**CARLTON COTTAGE
HIGH STREET : ANGMERING VILLAGE
WEST SUSSEX : BN16 4AW**

31st March, 2015

Ref : A/165/14 Littleworth House

PROPOSED FLOOR PLAN

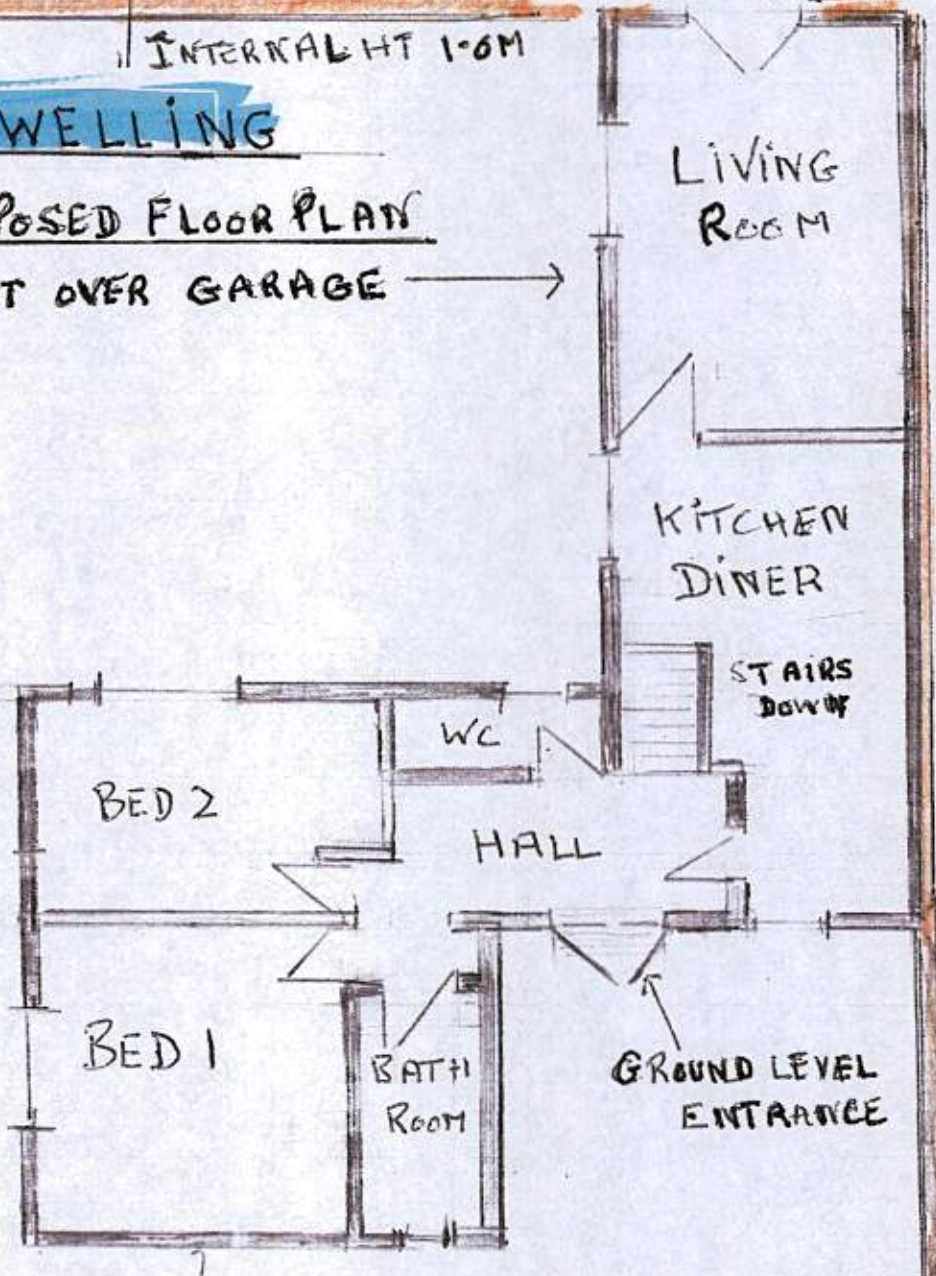
Mr. Thomas seems to be totally oblivious of the fact that the wall at the western end of his property also forms the eastern boundary of my property. As I party wall between our houses I surely should have some say in whether or not it should be destroyed.

I apologise as I have now located Plan G. However the fact remains that the plans do not show any direct access from Littleworth House to the new build other than by lifting the up and over door to the garage block. The application form says there should be four parking spaces, this is obviously a mistake.

PICTORIAL VIEW PROPOSED ROOF

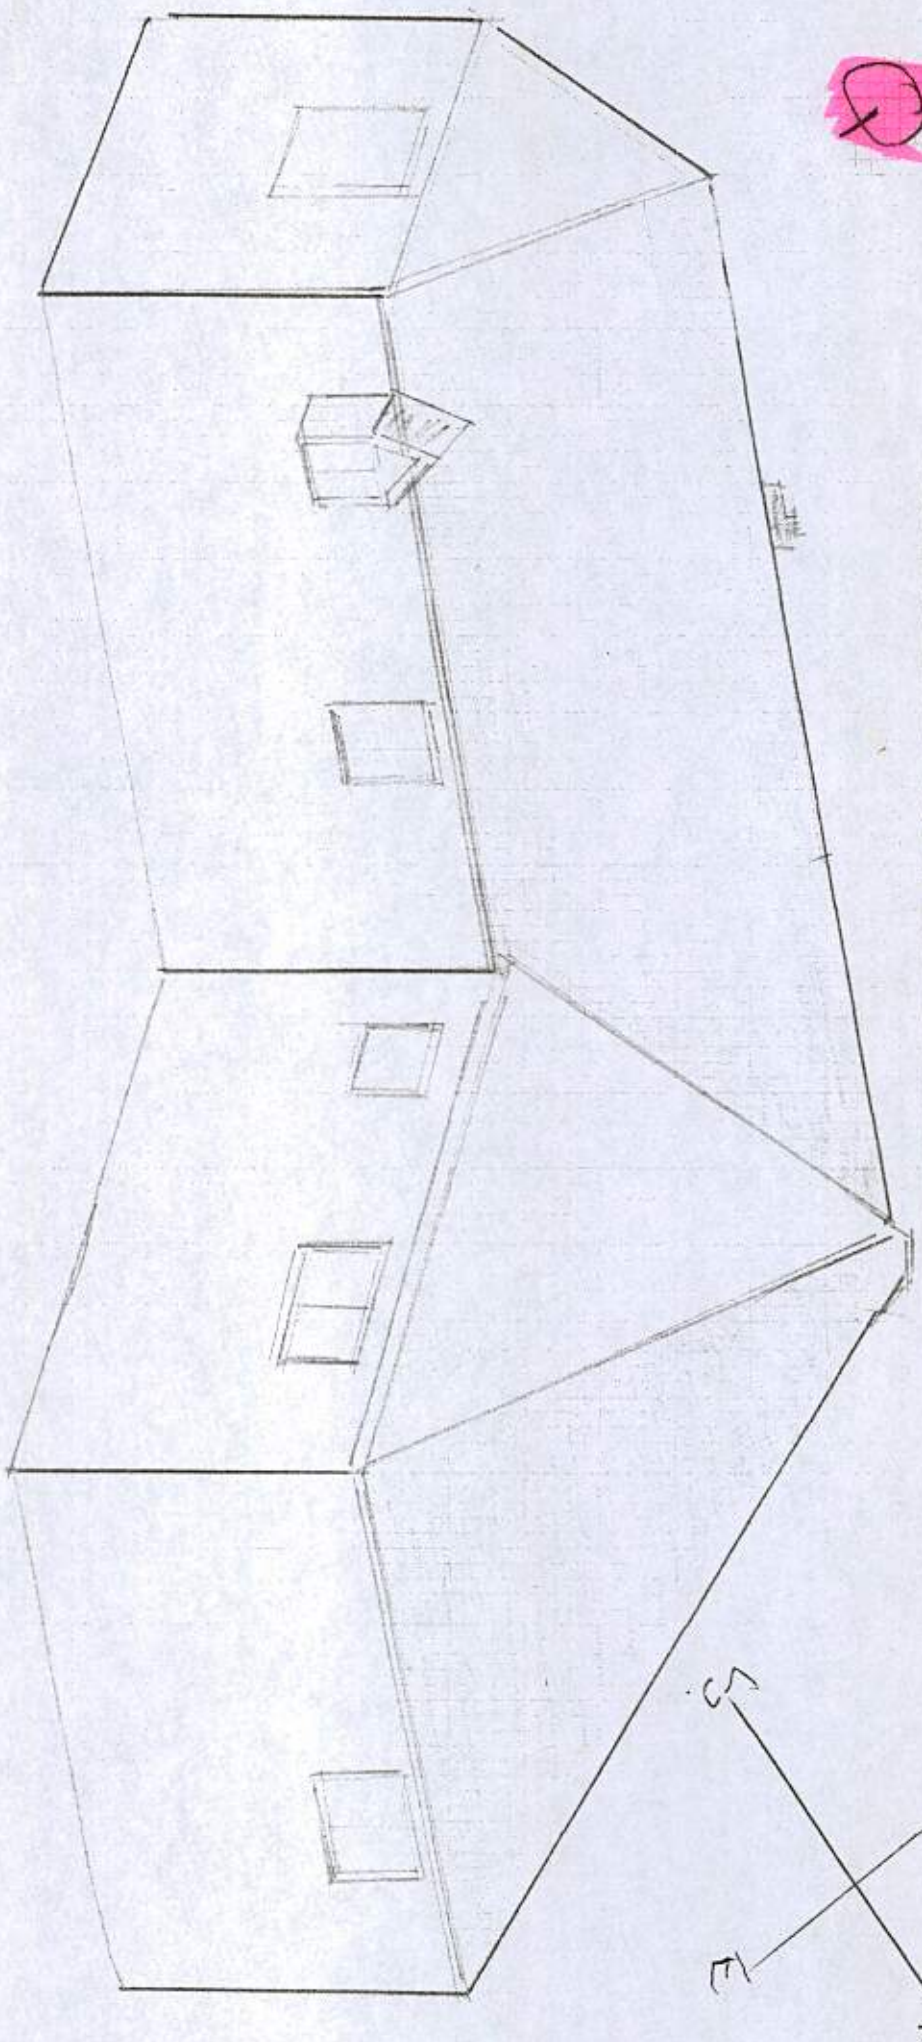
Major changes to the now obsolete plans include, a.) a completely revised roof structure: b.) a change from parking bays to garages in a different location and revised access from Littleworth House.
